Peartree Hill Solar Farm

Environmental Statement Addendum Revision 2

Application Document Ref: EN010157/APP/8.2

August 2025

- | No. | Viewpoint  |

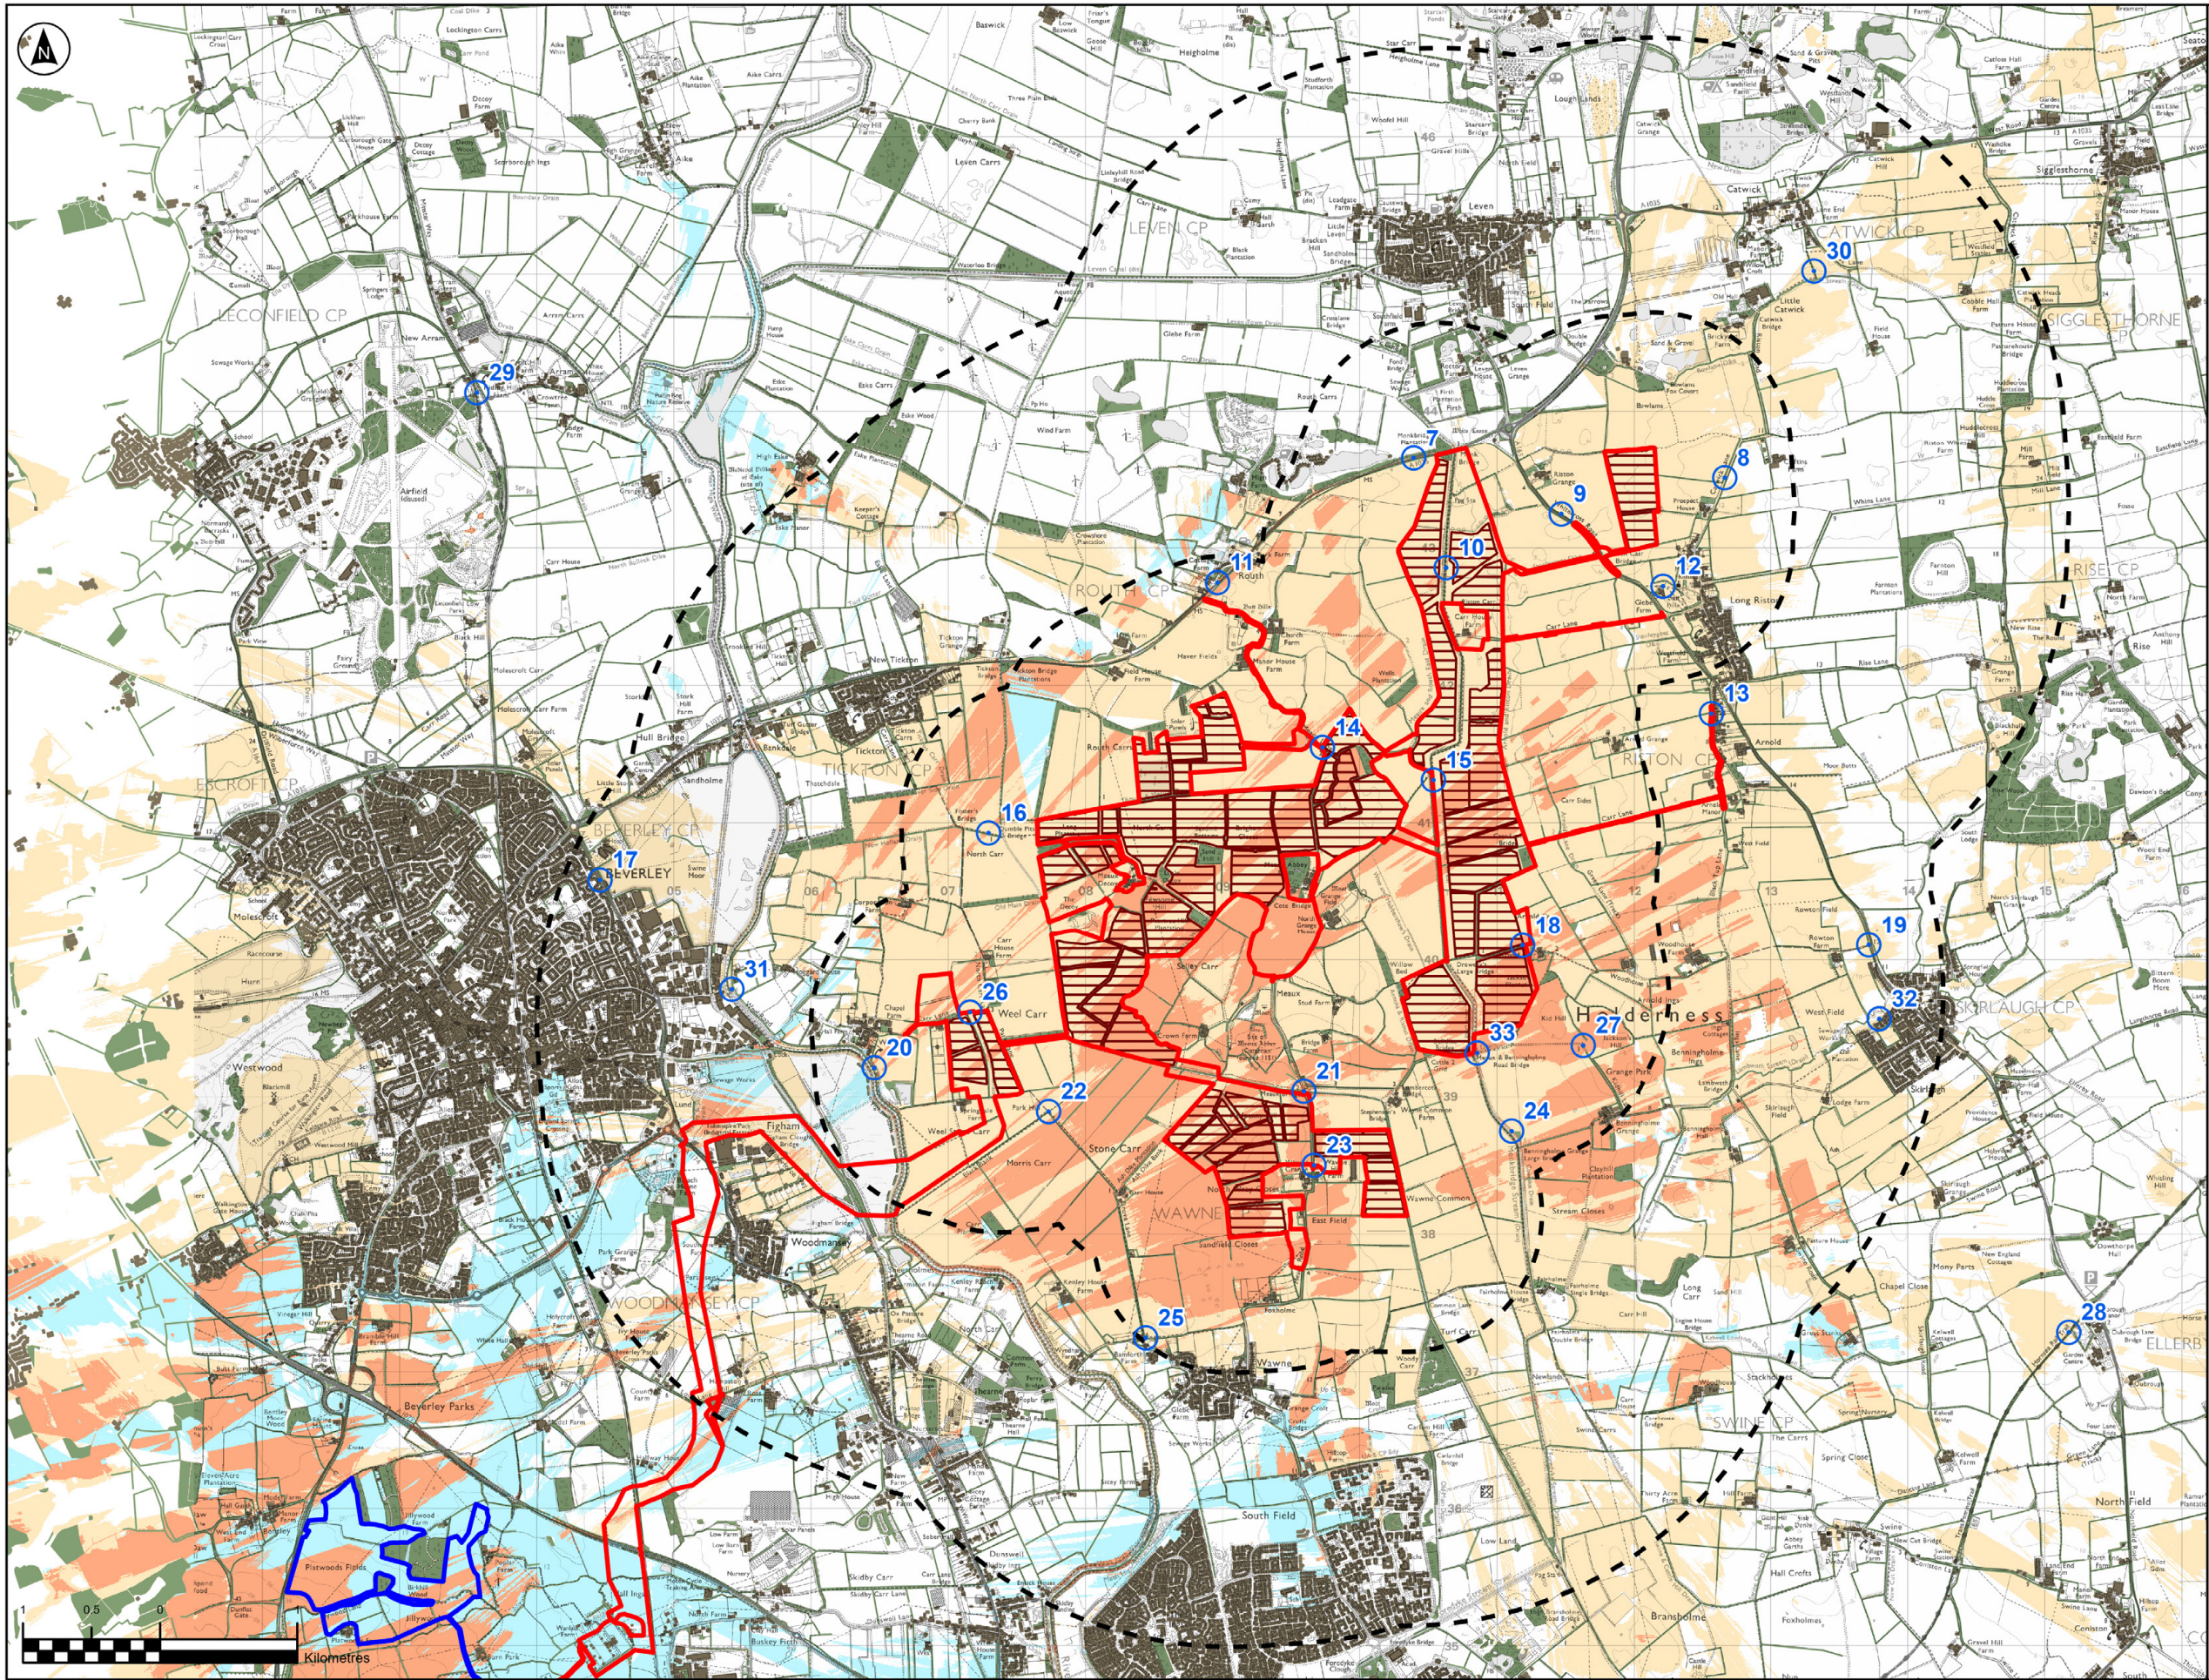
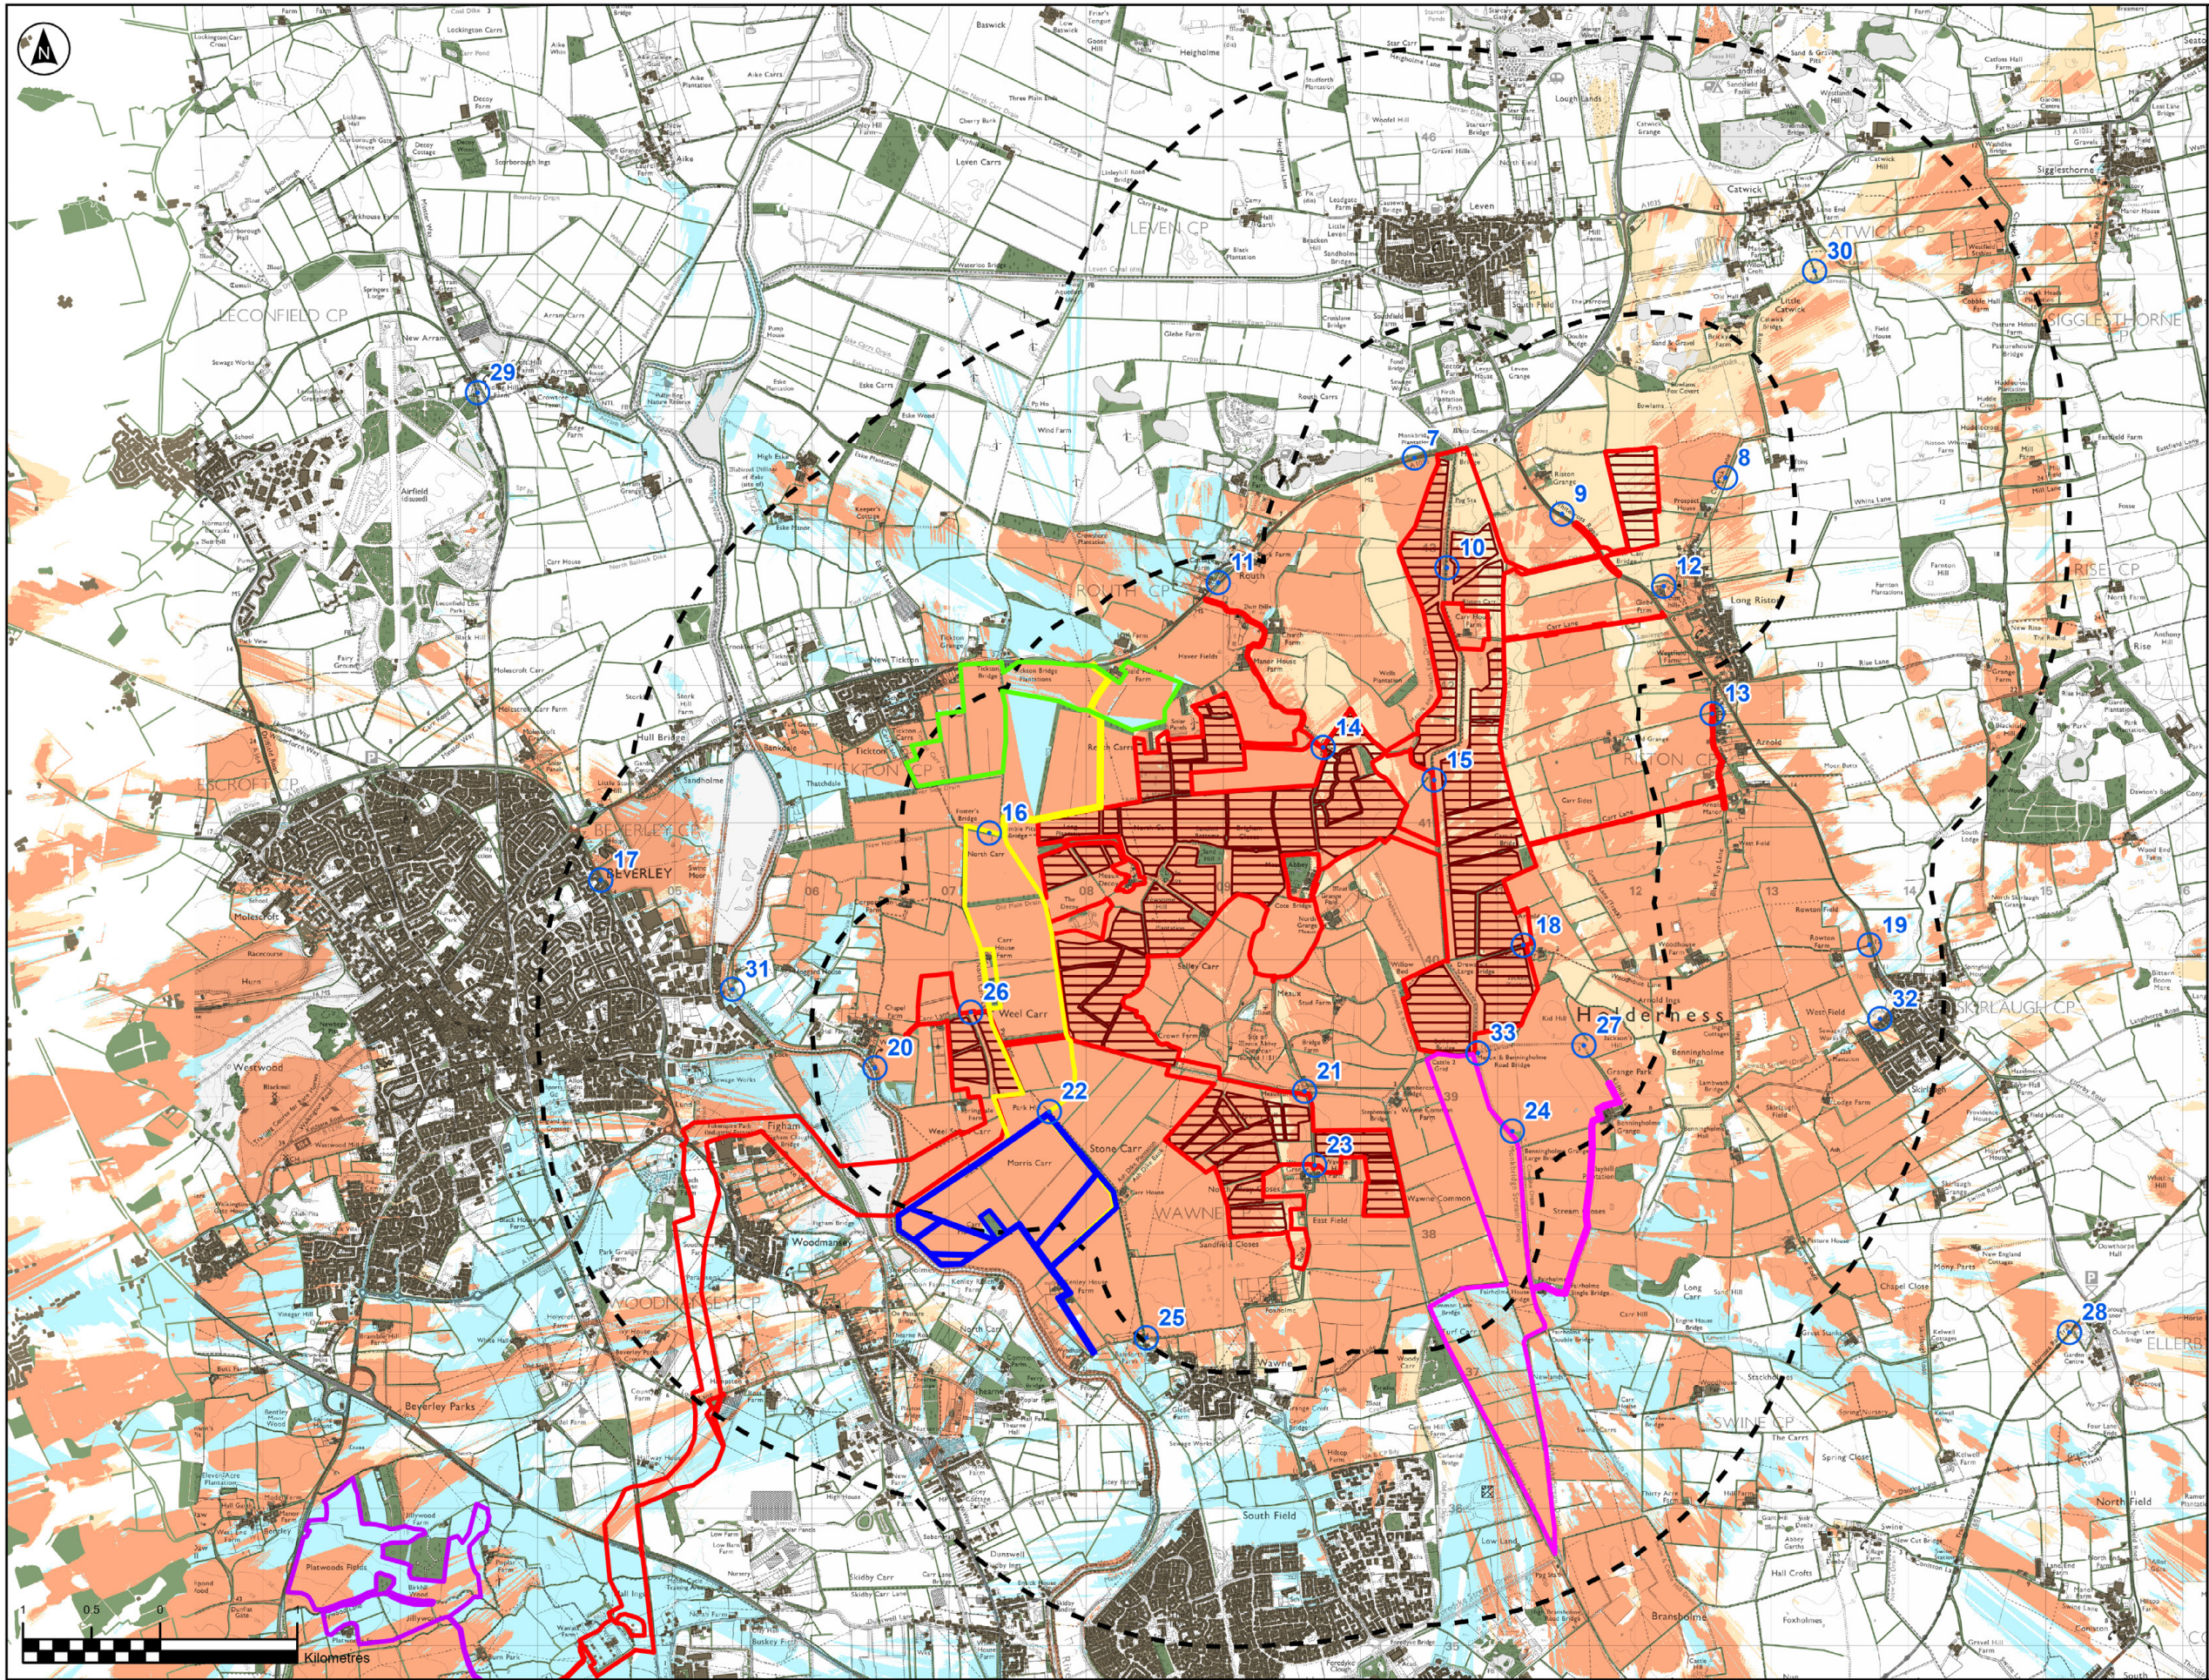
Document reference	Reason for amendment	ES Amendment August 2025
ES Volume 4, Appendix 15.2: Cumulative Landscape and Visual Impact Assessment [APP-144]	<p>Response to the ExA's First Written Questions [PD-008] (1.10.28 c)).</p> <p>Updates required to include a missing receptor ('Tickton PRow located between Tickton and Weel') in summary paragraph 3.8.4.</p> <p>When correcting the paragraph, the Applicant noted that three receptors had been included in paragraph 3.8.4 incorrectly. Updates required to move these receptors to a new paragraph.</p>	<p>A new paragraph 3.8.3 is added, which states:</p> <p>"For some receptors it is acknowledged that the addition of the five schemes considered in this cumulative assessment, in addition to the Proposed Development, would increase the geographic area where effects would be felt. However, they would not create significant cumulative effects beyond those already identified as being created by the Proposed Development alone. Those receptors to which this applies are:</p> <ul style="list-style-type: none"> • Meaux Lane/Meaux Road; <ul style="list-style-type: none"> ○ Cumulative effects identified, but overall not greater than those identified for the Proposed Development alone. • PRow Riston footpath no.2; <ul style="list-style-type: none"> ○ Cumulative effects identified, but overall not greater than those identified for the Proposed Development alone. • PRow Riston footpath no.1;
